Ruth Hambleton
 Sent: 26 April 2012
 To: Planningecons
 Subject: RE: Planning Consultation on: BR/60/12/

APPLICATION BR/60/12/
NO:
Registered: 16th March
 2012
Site 5 Crescenta Walk Bognor Regis PO21 2YA
Address:

Grid Reference: 492311 99239
Description of Works: Outline application with some matters reserved for division of boundary & erection of new detached 3 bed dwelling house

client: Mr & Mrs J Hiley
Drawing Title: GA Proposed Elevations
Scale: 1:100@A3
Date: February 12
Job nos.: 039 ADS-KS
Drawing nos.: 004
Rev: *
Status: Planning

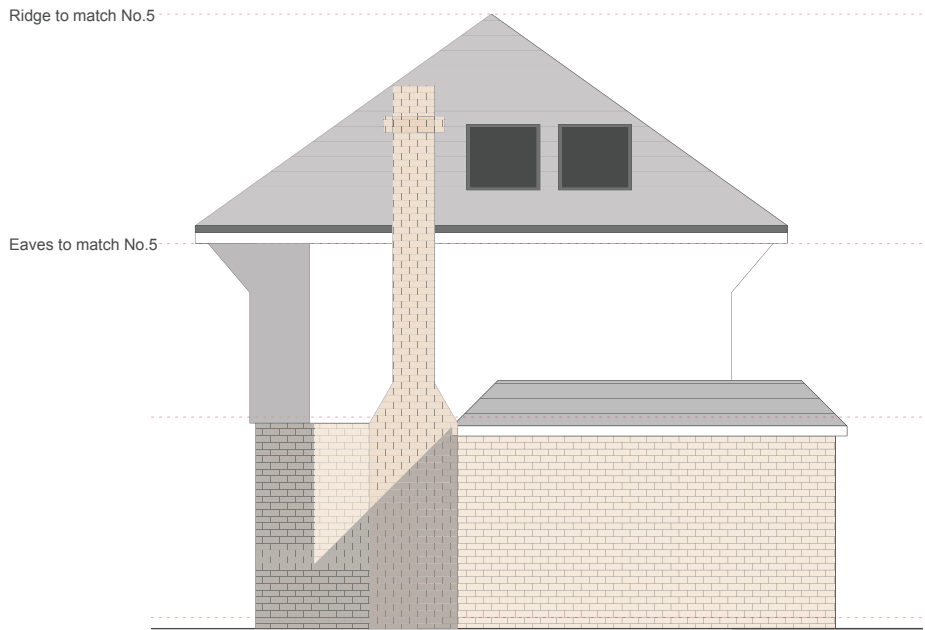
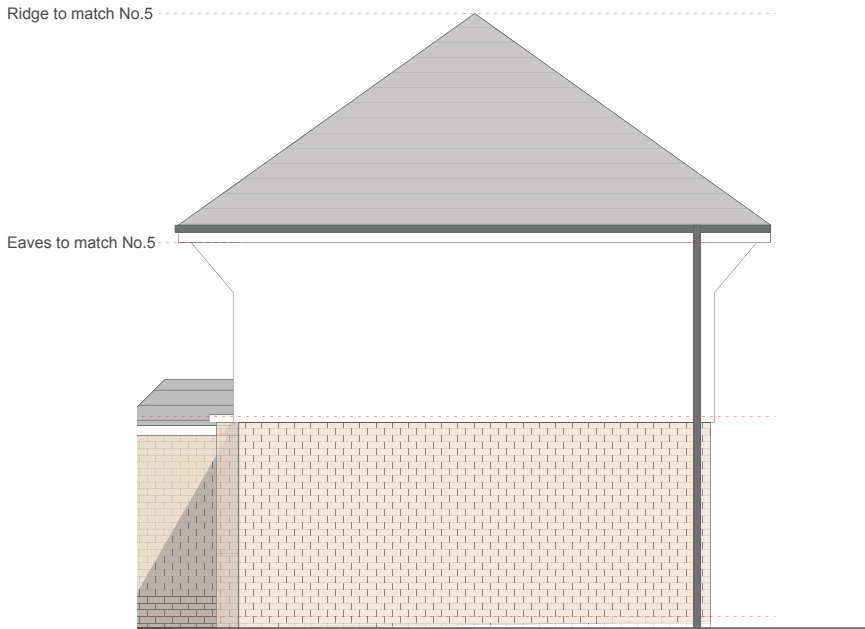
NO OBJECTION was raised to the development of this plot but the Committee expressed concerns that the proposed dwelling is out of character and not in keeping with the surrounding area
